REQUEST

Current Zoning: B-1 (neighborhood business) and R-5 (single family residential)
Proposed Zoning: NS (neighborhood services)

Approximately 0.76 acres located on the western side of Tuckaseegee Road between Camp Green Street and Berryhill Road.

The petition proposes to redevelop the site to allow all uses in the NS district in up to 16,000 square feet of building area.

REZONING PETITION
#2020-157

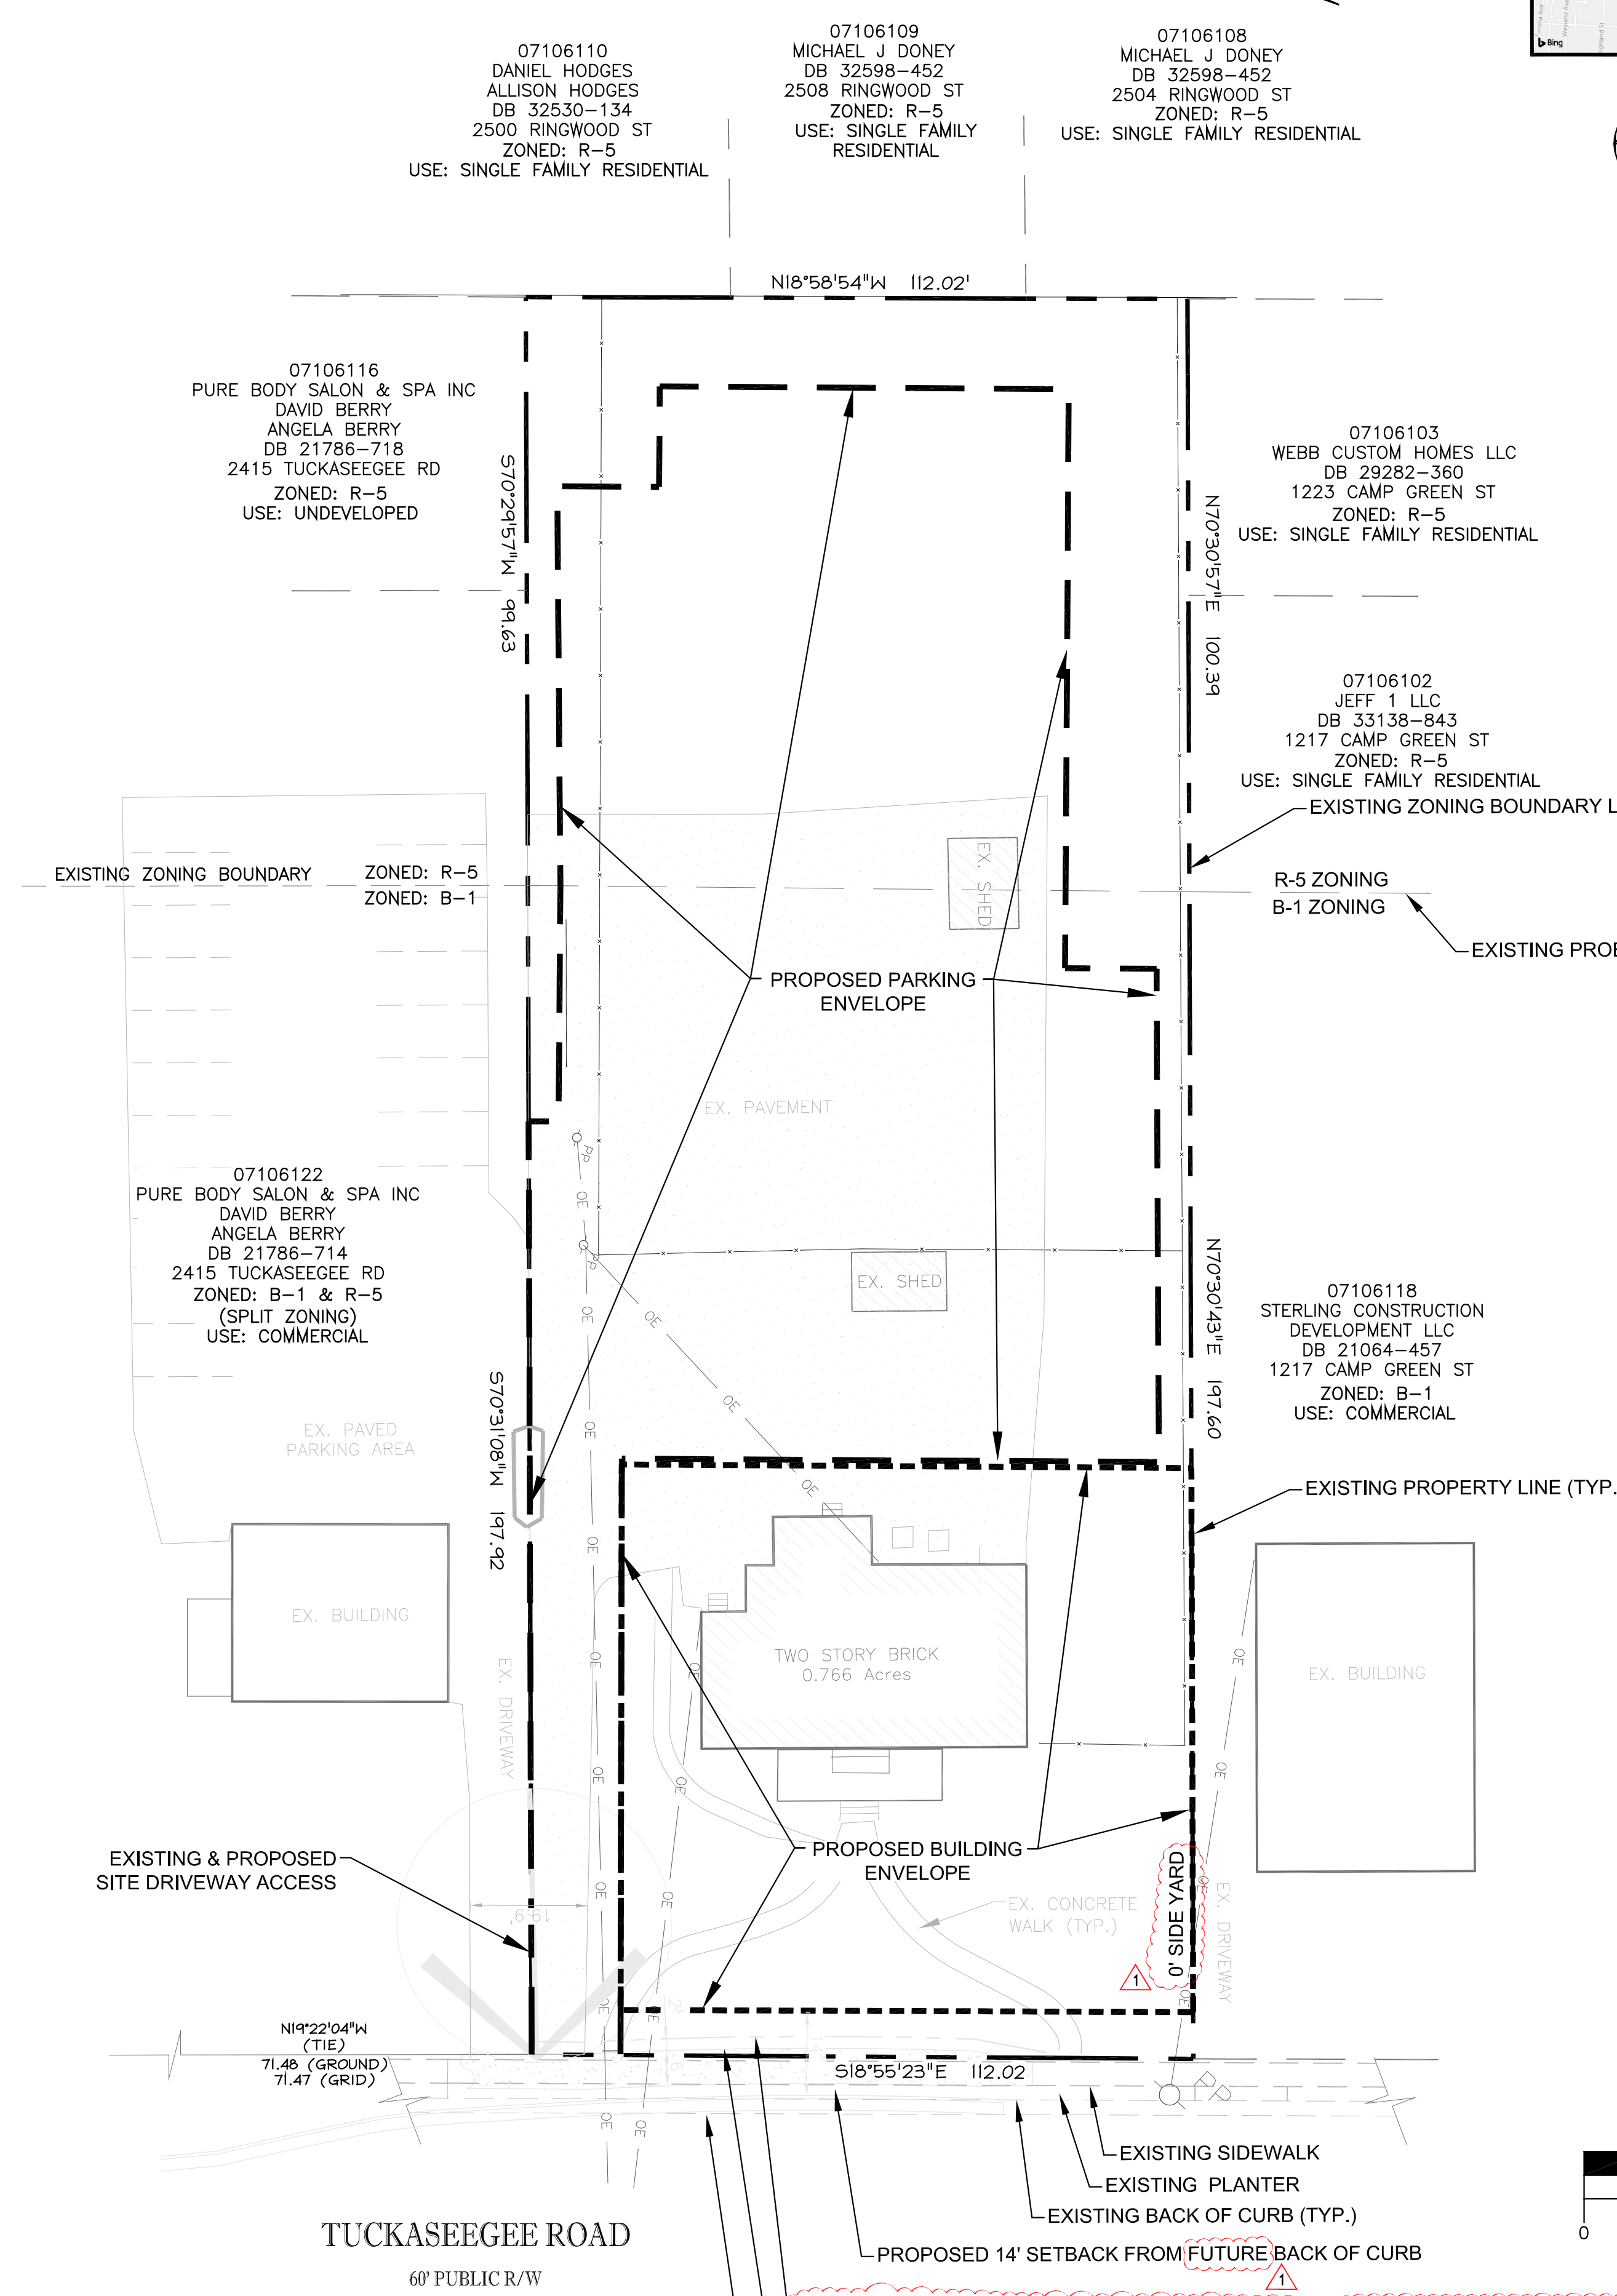
1. Label and dimension the curb and gutter from the centerline for each road on the site plan.
2. Revisions are needed on the site plan and conditional note (Section 7.B) to relocate the proposed 8-foot planting strip to the Tuckaseegee Road back of curb, separating the proposed 6-foot sidewalk from the roadway, as required within Chapter 19-174 of the City Code, to allow the planting strip to function as necessary.

3. The proposed building setback should be roughly the same as the predominant setback on the block and adjacent buildings. Please revise proposed building envelope accordingly.

4. Provide a minimum 10' vegetative buffer where abutting single family residential zoning or use.
5. Add the following urban design notes as listed in staff comments to the site plan:
